CITY OF ALBUQUERQUE

November 2, 2022

Re: L & F- Cultivation
4415 Prospect Ave. NE
Traffic Circulation Layout
Engineer's/Architect's Stamp XX-XX-XX (H17-D014)

Based upon the information provided in your submittal received 10-18-22, the above referenced plan cannot be approved for Building Permit until the following comments are addressed:

5 BICYCLE RACK
SCALE: 3/4"=1'-0"

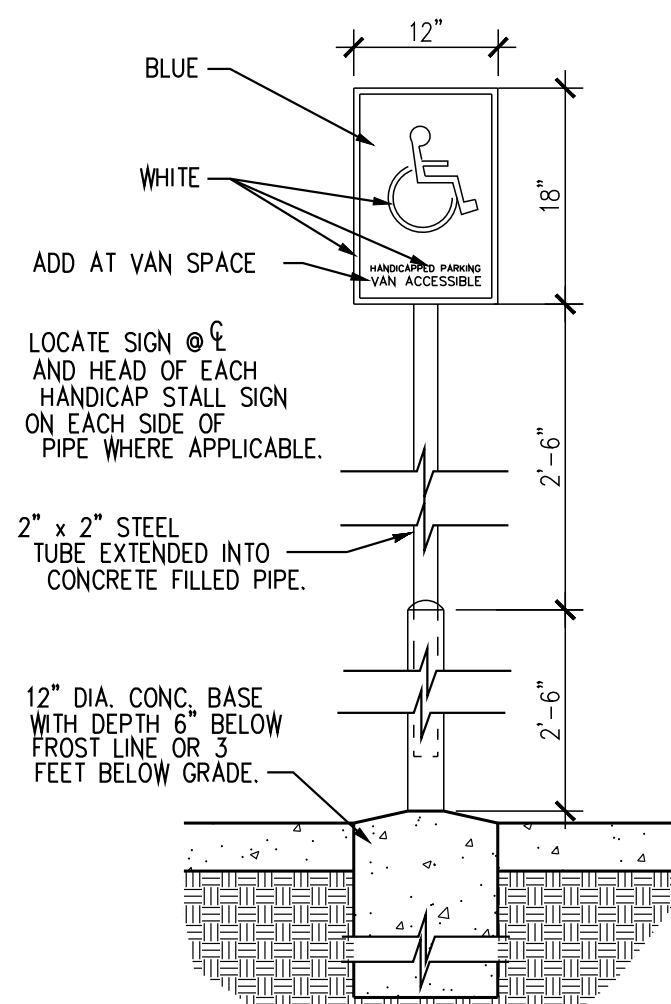
- a. The rack shall be a minimum 30 inches tall and 18 inches wide.
 - b. The bicycle frame shall be supported horizontally at two or more places. Comb/toaster racks are not allowed.

- c. The rack shall be designed to support the bicycle in an upright position. See the IDO for additional information.
 - d. The rack allows varying bicycle frame sizes and styles to be attached.

- e. The user is not required to lift the bicycle onto the bicycle rack.
 - f. Each bicycle parking space is accessible without moving another bicycle.

19. Bicycle racks shall be sturdy and anchored to a concrete pad.
20. A 1-foot clear zone around the bicycle parking stall shall be provided.
21. Bicycle parking spaces shall be at least 6 feet long and 2 feet wide.

6 HANDICAP PARKING SIGN
SCALE: 3/4"=1'-0"

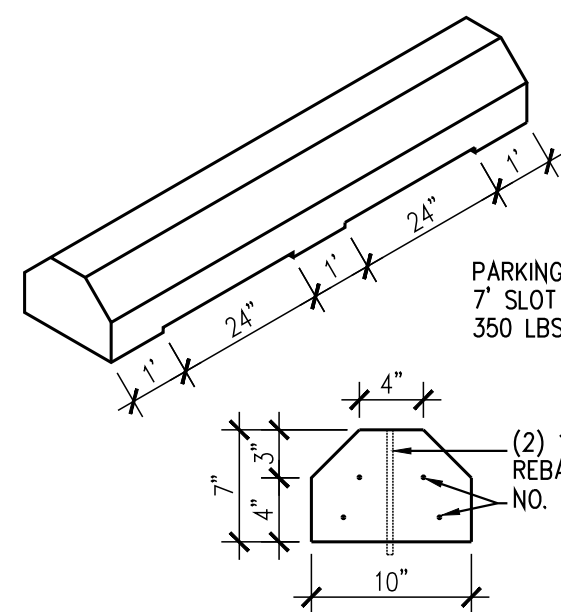
12. The ADA accessible spaces must include an access aisle. Van accessible aisles should be 8ft wide; all others should be 5ft wide.
13. The ADA accessible parking sign must have the required language per 66-7-352.4C NMSA 1978 **"Violators Are Subject to a Fine and/or Towing."** Please call out detail and location of signs.

1 DISABLED PARKING DETAIL
3/16"=1'-0"

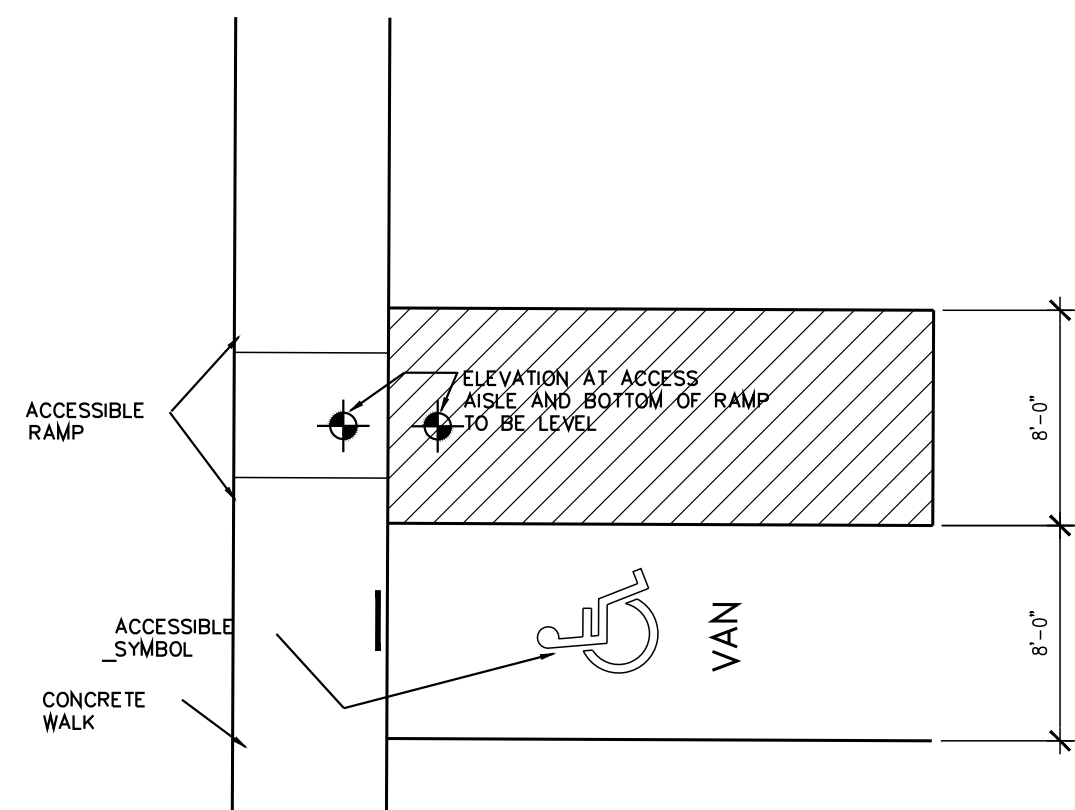
14. The ADA access aisles shall have the words **"NO PARKING"** in capital letters, each of which shall be at least one foot high and at least two inches wide, placed at the rear of the parking space so as to be close to where an adjacent vehicle's rear tire would be placed. (66-1-4.1.B NMSA 1978)

TRAFFIC CIRCULATION LAYOUT

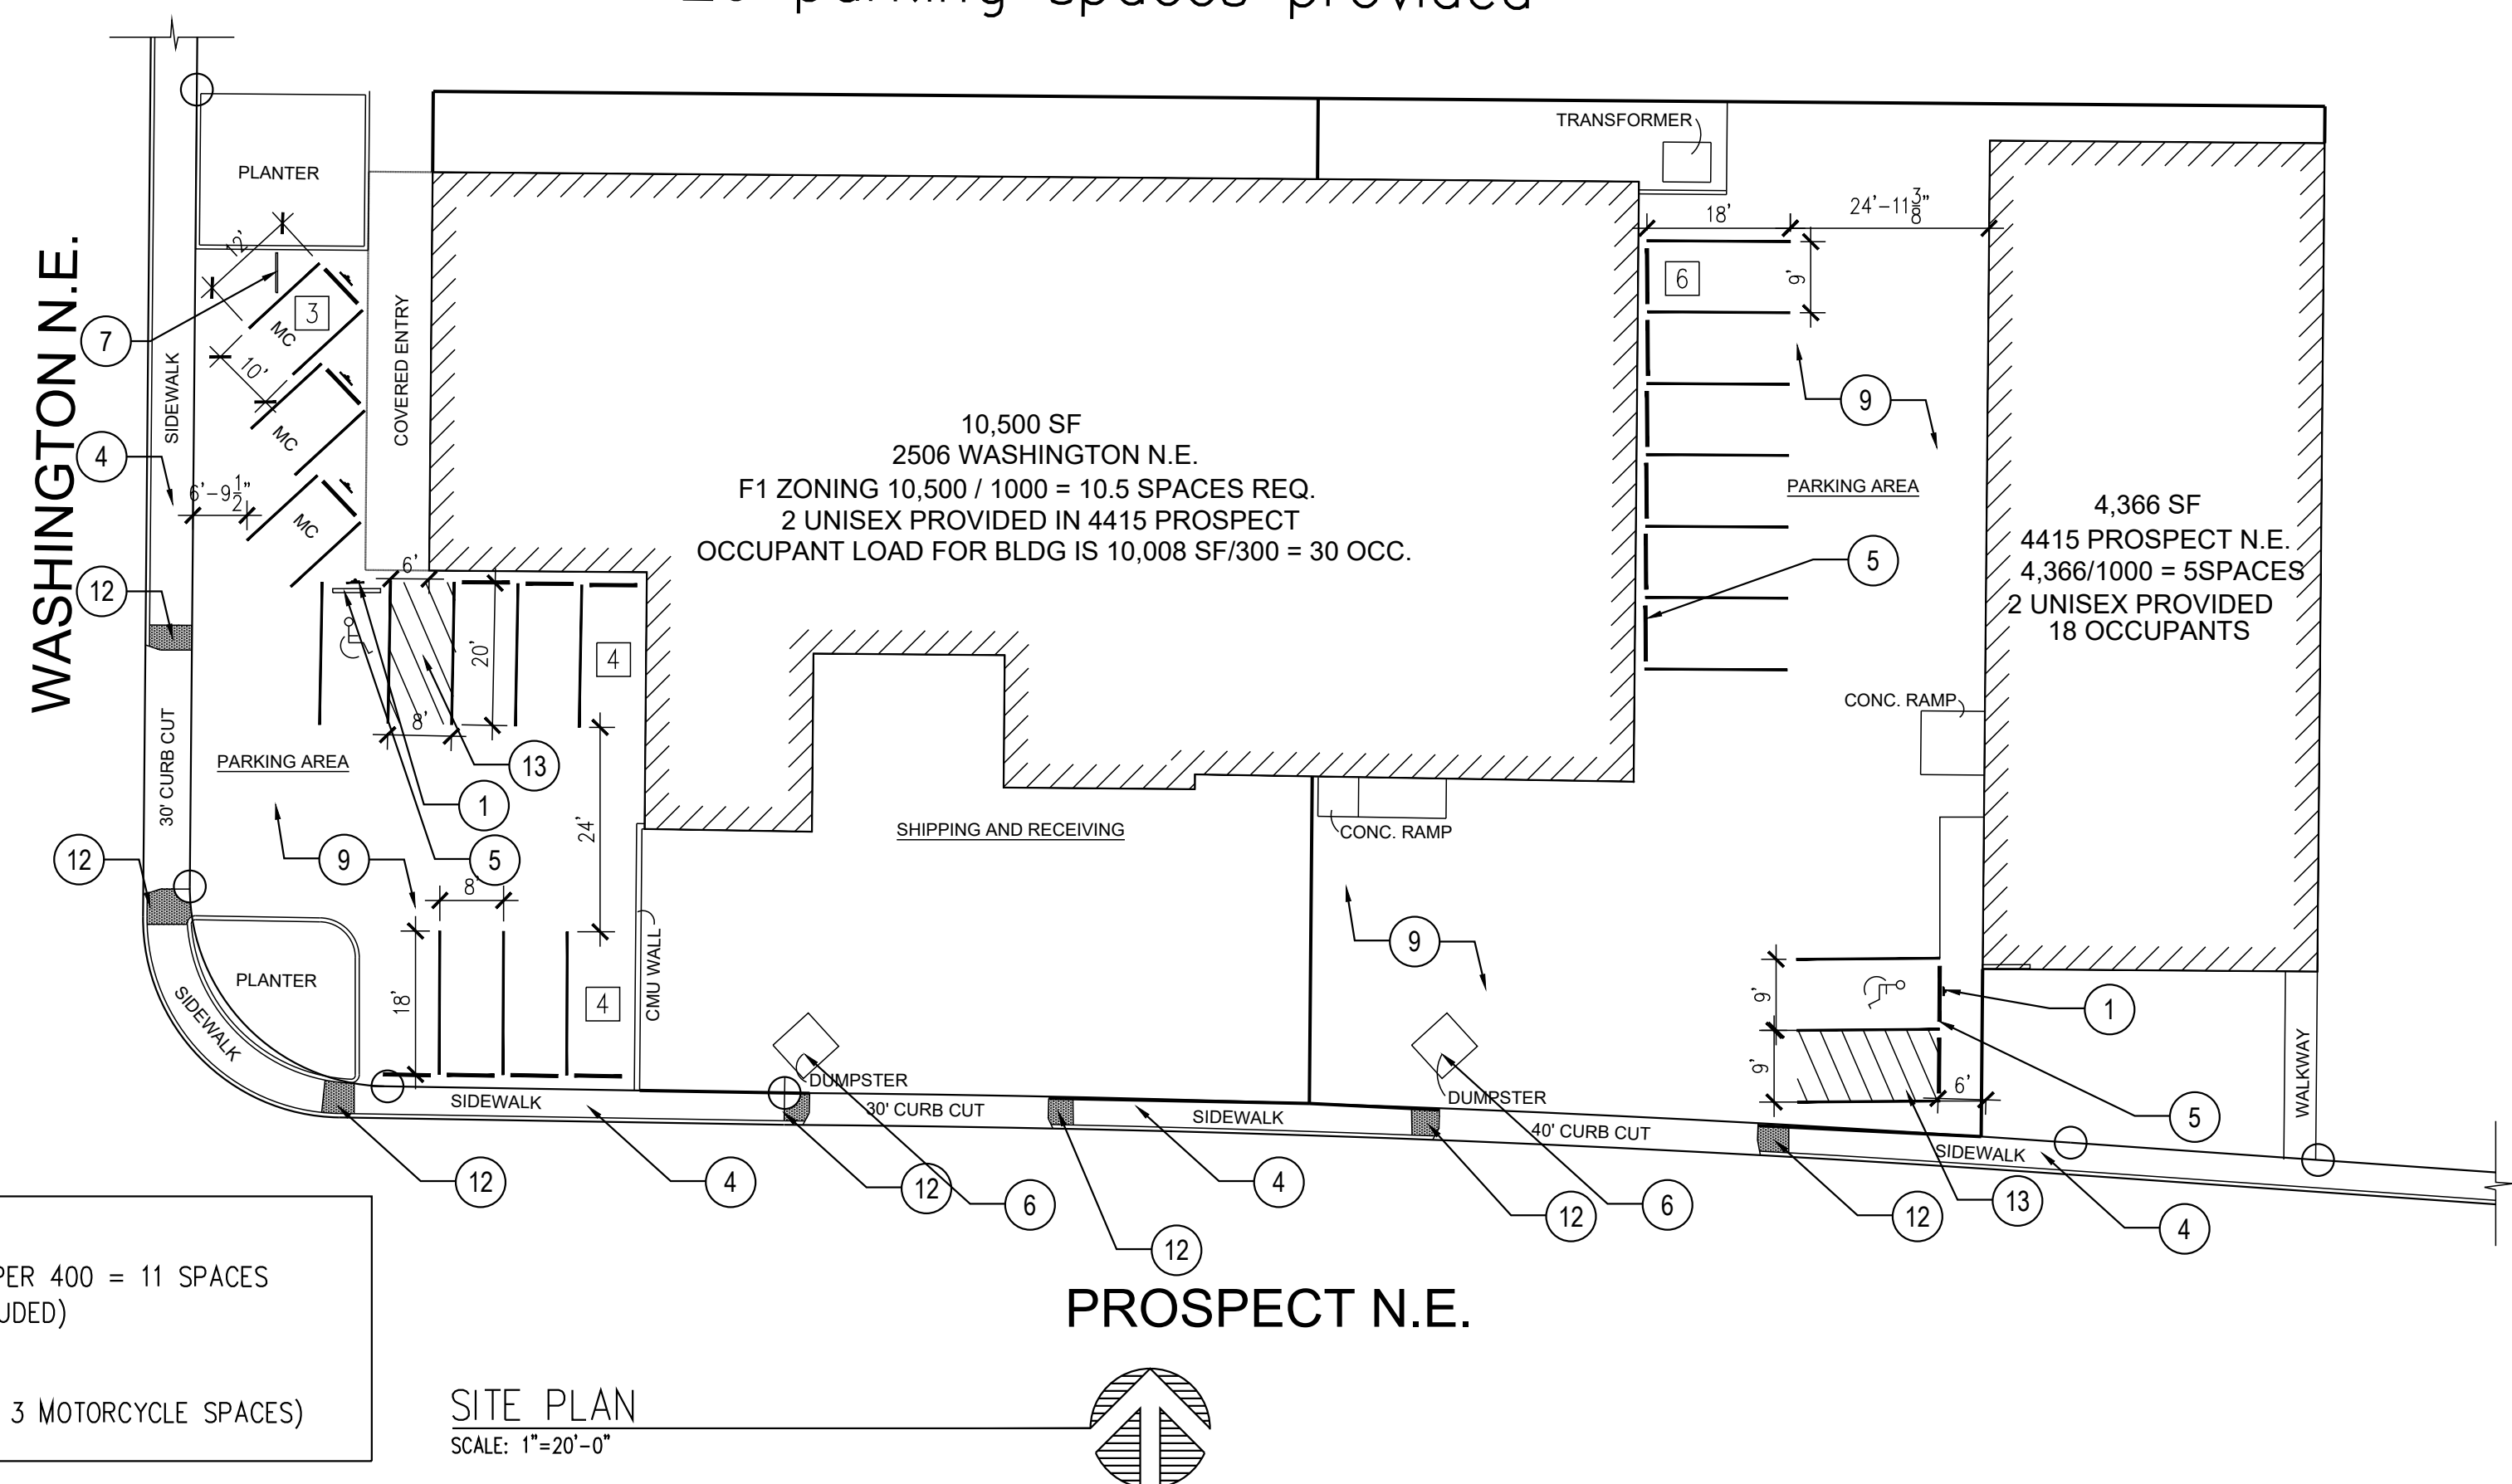
1. Please show a vicinity map showing the location of the development in relation to streets and well-known landmarks.
2. List the number of Motorcycle and Bicycle parking spaces required by the IDO.

3. The traffic circulation layout must be stamped, signed, and dated by an engineer or architect licensed in the state of New Mexico.
4. Identify the right of way width, medians, curb cuts, and street widths on Washington NE and Prospect Ave NE.

5. Per the DPM (Distance from the Intersection Table), driveway access off Prospect Ave. must be 50 ft away from the intersection of Washington and Prospect Ave. and driveway access off Washington should be 75 ft. away from the intersection. Please clearly show this distance on the site-plan.

8. Provide sidewalk width.
9. Clarify existing property lines and proposed property lines.
10. Please list the width and length for all existing and proposed parking spaces. Some dimensions are not shown.

15. ADA curb ramp at the corner of Washington St. and Prospect Ave. must be updated to current standards and have truncated domes installed.
16. Motorcycle parking spaces shall be designated by its own conspicuously posted upright sign, either free-standing or wall mounted per the zoning code.

17. The pavement marking "MC" should be shown in the opposite direction for Motorcycles entering the parking space.
18. All bicycle racks shall be designed according to the following guidelines:

22. Show all drive aisle widths and radii. Some dimensions are not shown.
23. The minimum drive aisle dimensions are shown below

24. Per the IDO, a 6 ft. wide ADA accessible pedestrian pathway is required from the public sidewalk to the building entrances. Please clearly show this pathway and provide details.

25. Per DPM, a 6 ft. wide ADA accessible pedestrian pathway is required from the ADA parking stall access aisles to the building entrances. Please clearly show this pathway and provide details.

26. ADA accessible pedestrian pathway should not be placed behind parking space or adjacent to a vehicular way. Vehicle and pedestrian/wheel chair conflicts should be avoided as much as possible.

27. Please define the ADA pathway, by labeling ramps, flush pavement, and show the building entrance.
28. All sidewalks along streets should be placed at the property line.

30. Please provide copy of Fire Marshal approval.
31. Show the clear sight triangle and add the following note to the plan: "Landscaping and signage will not interfere with clear sight requirements. Therefore, signs, walls, trees, and shrubbery between 3 and 8 feet tall (as measured from the gutter pan) will not be acceptable in the clear sight triangle.
